Planning Application Ref: M/155/18/PL

Location: 5 Central Drive, Middleton-On-Sea, PO22 7TT

Description of works: Replacement dwelling (resubmission following M/114/18/PL).

PROJECT TITLE Proposed development at 5 Central Drive	DRAWING TITLE Proposed Elevations		No	REVISION	DATE
	STATUS Planning Application				
	SCALE 1:100 @ A3	DATE 14.12.2018			
	DRAWN BY AP	DRAWING No PA-270-07

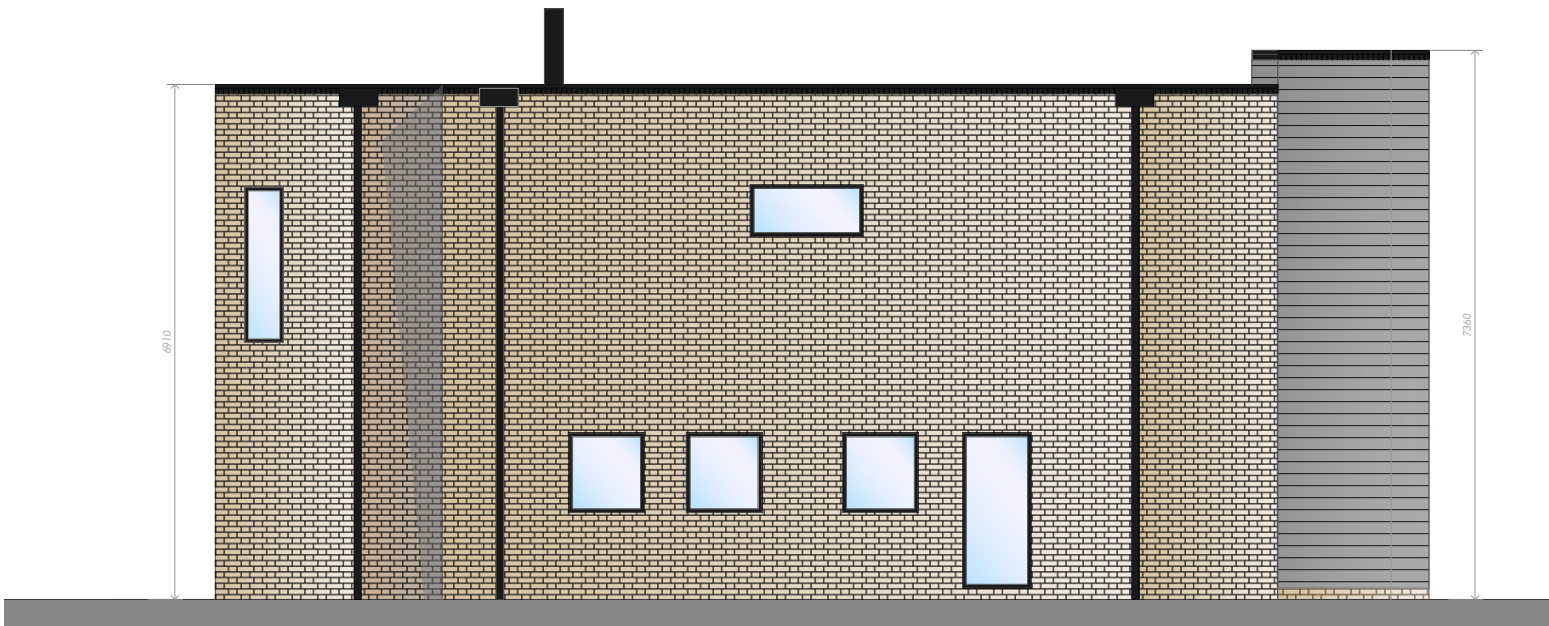
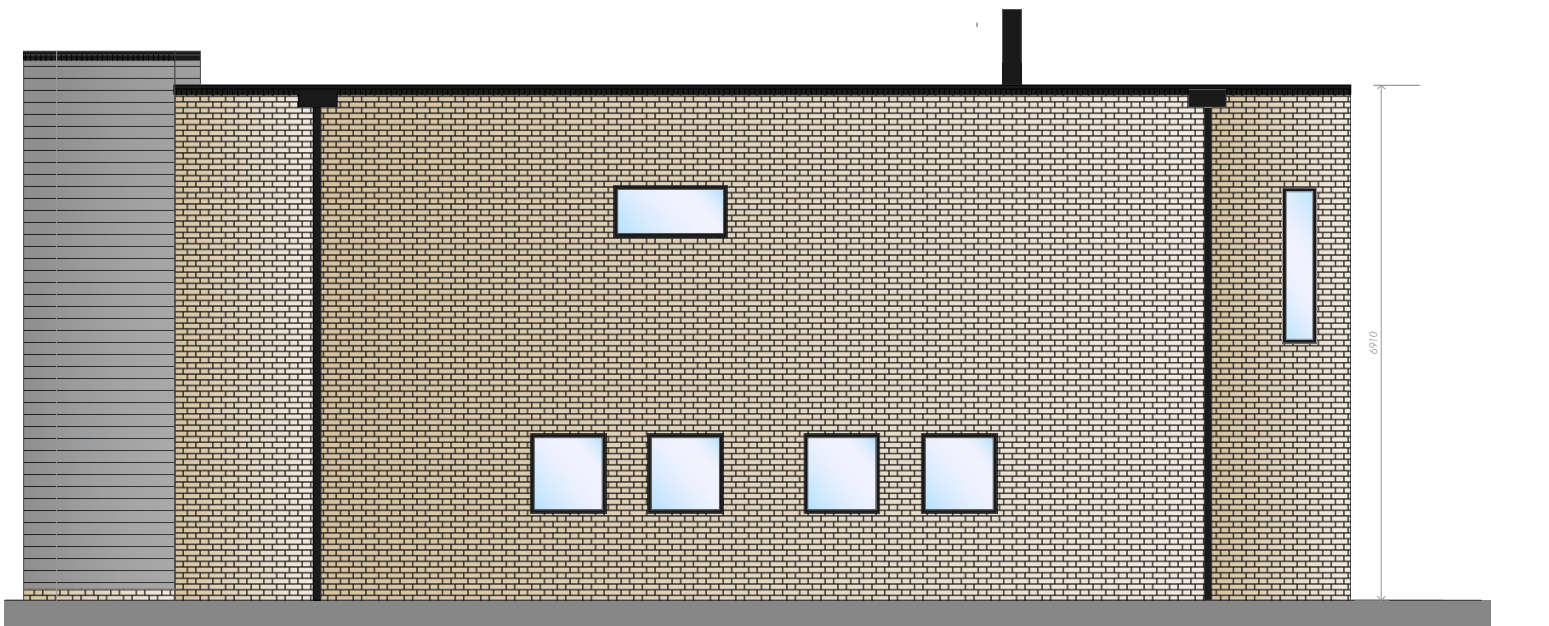
- Facilitation pruning will be necessary to accommodate the latest building design, which has a higher west facing elevation – further impacting on the ongoing health and vitality of this impressive tree. It is perhaps not worthy of a Tree Preservation Order, although this is primarily due to its having outgrown its context rather than any other condition or visual related property.

- In respect of facilitation pruning proposed for Monterey cypress tree (T02) – where branches are to be shortened back the final cuts are to be made at the correct angle shown in BS3998:2010 and adjacent to a live bud or lateral.

Tree Retention and Protection Plan

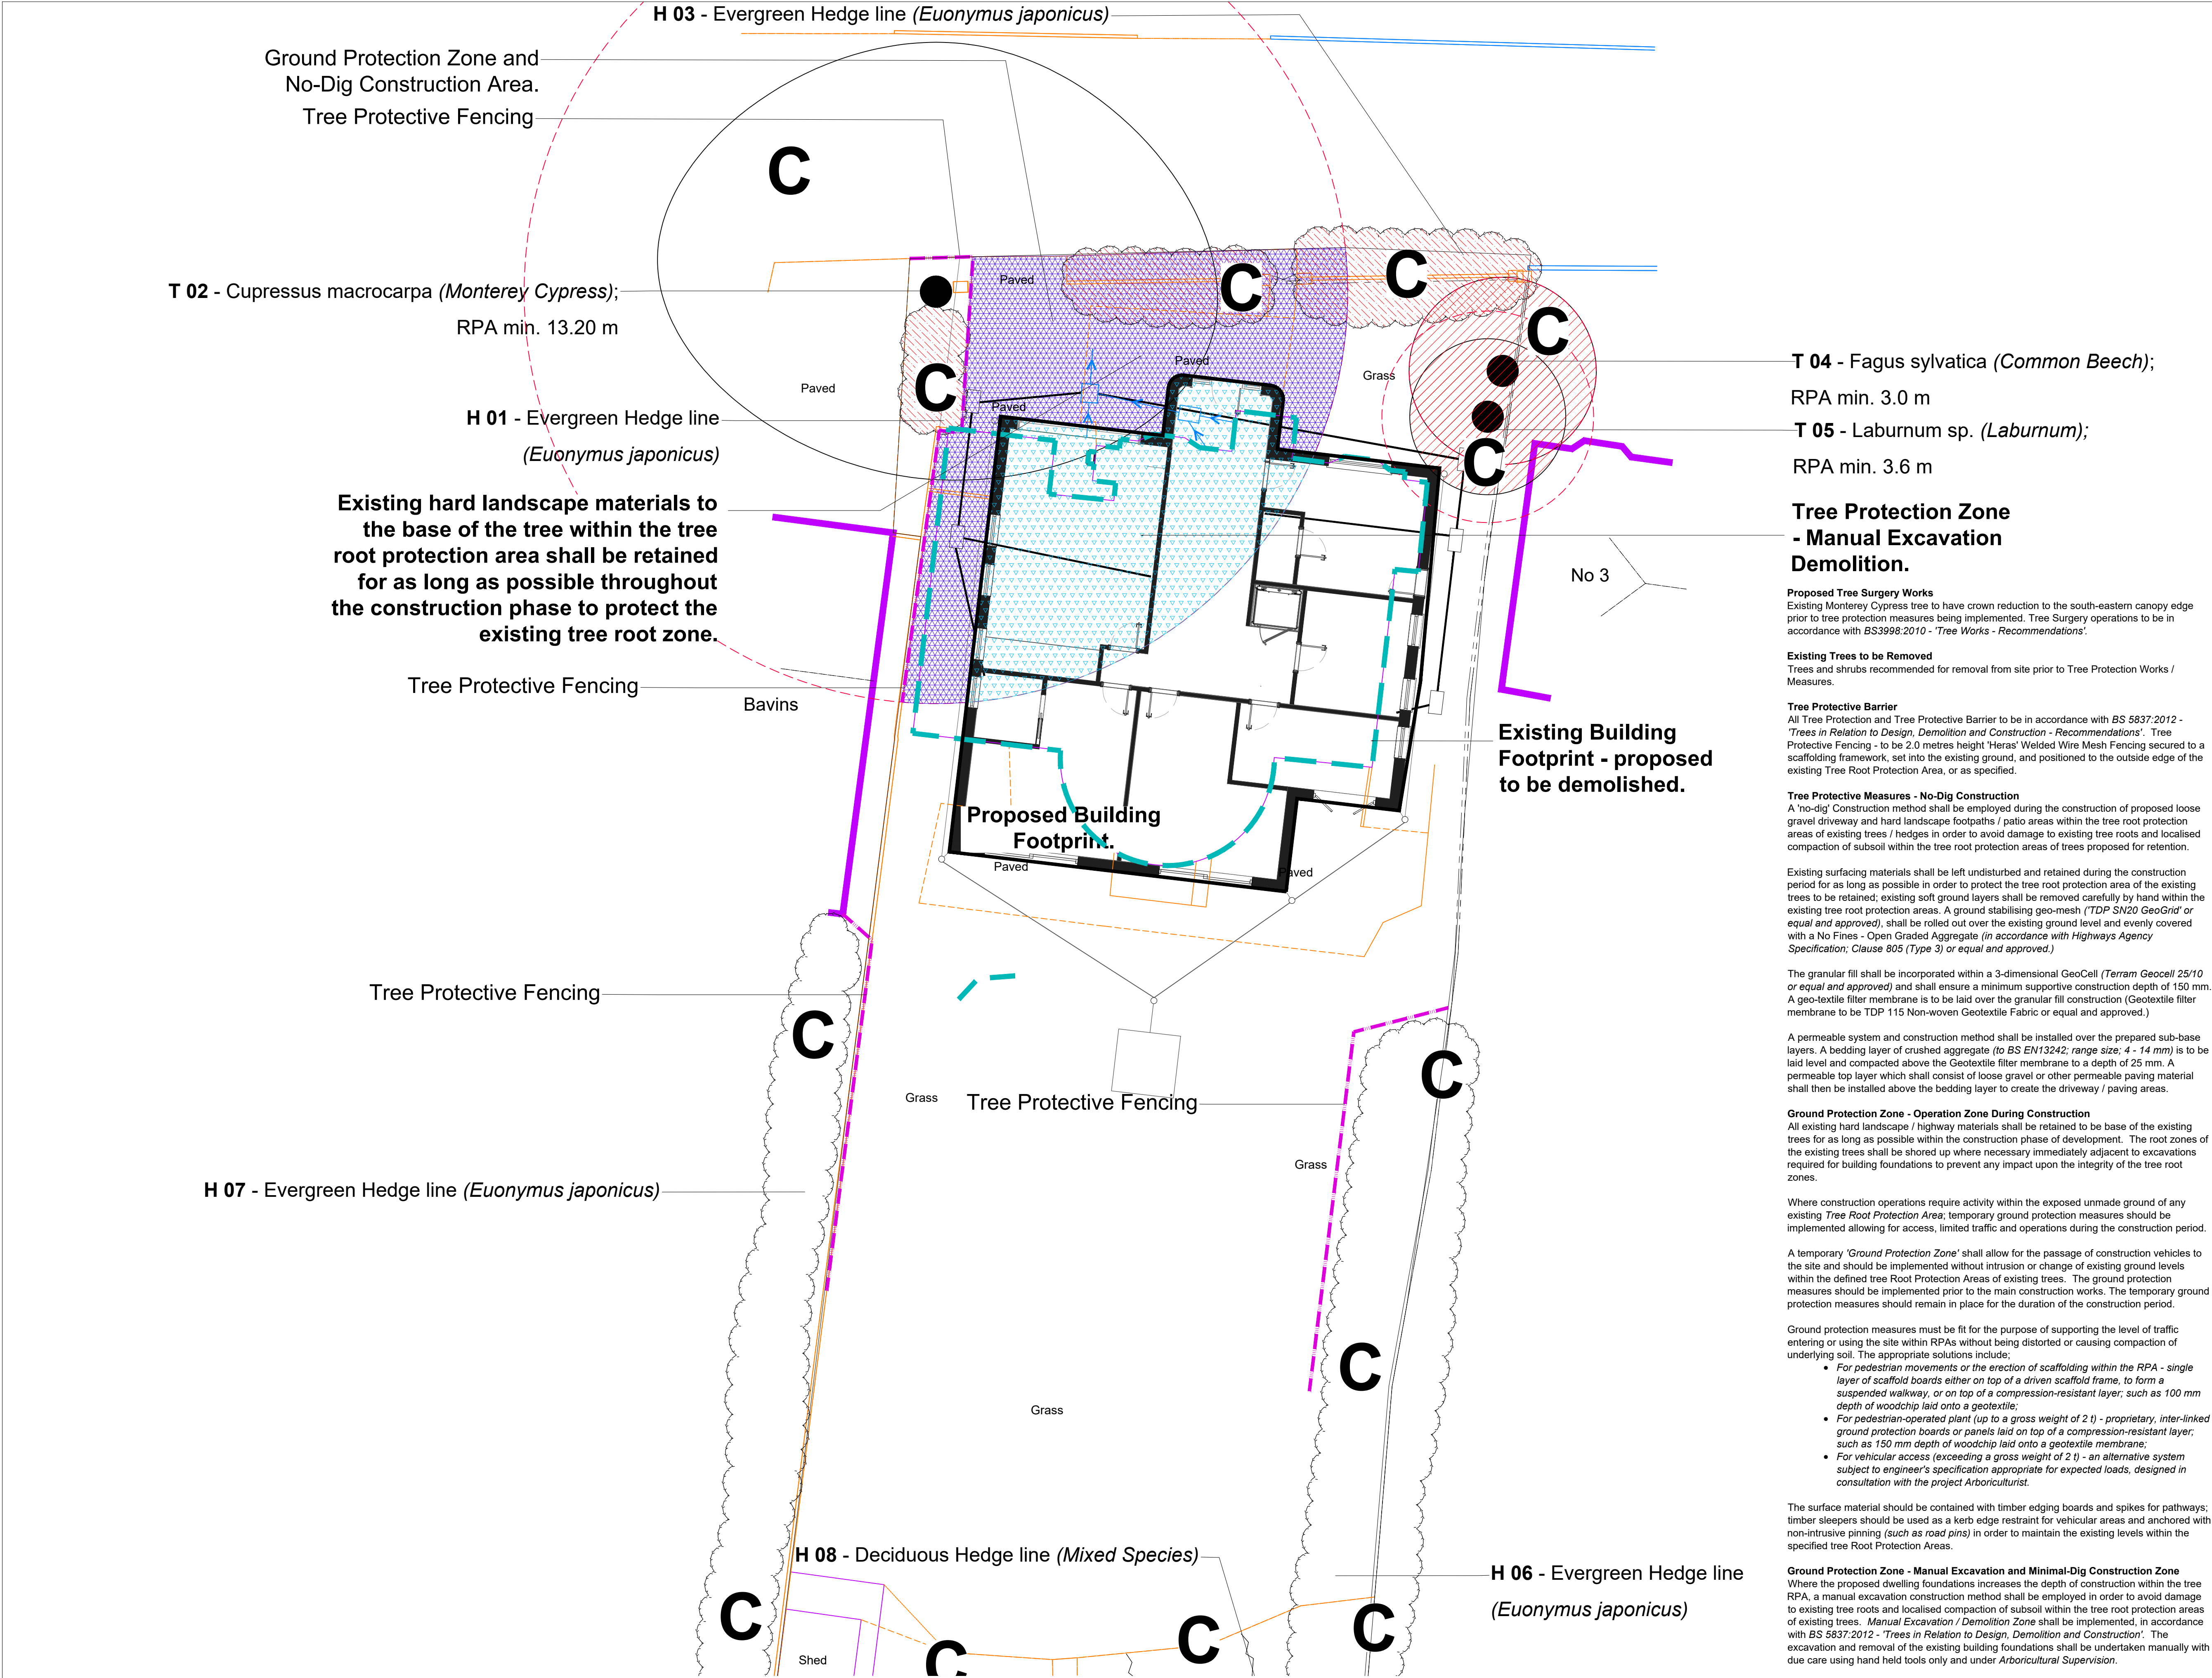
- Before the site is occupied or any machinery is introduced to the site or demolition work or construction work or alterations to existing ground levels takes place a **PRE-COMMENCEMENT Site Meeting** is to take place between the Arun DC Tree Officer and the Arboricultural Expert representing the site owners – at this meeting all protective fencing will be inspected along with ground protection measures – they will be assessed to verify that they are ‘Fit for Purpose’ as required under British Standard 5837:2012 and have been erected and positioned exactly as shown on the **Tree Retention and Protection Plan (LLD1671-ARB-DWG-002, Rev.01, 26.03.19)**.
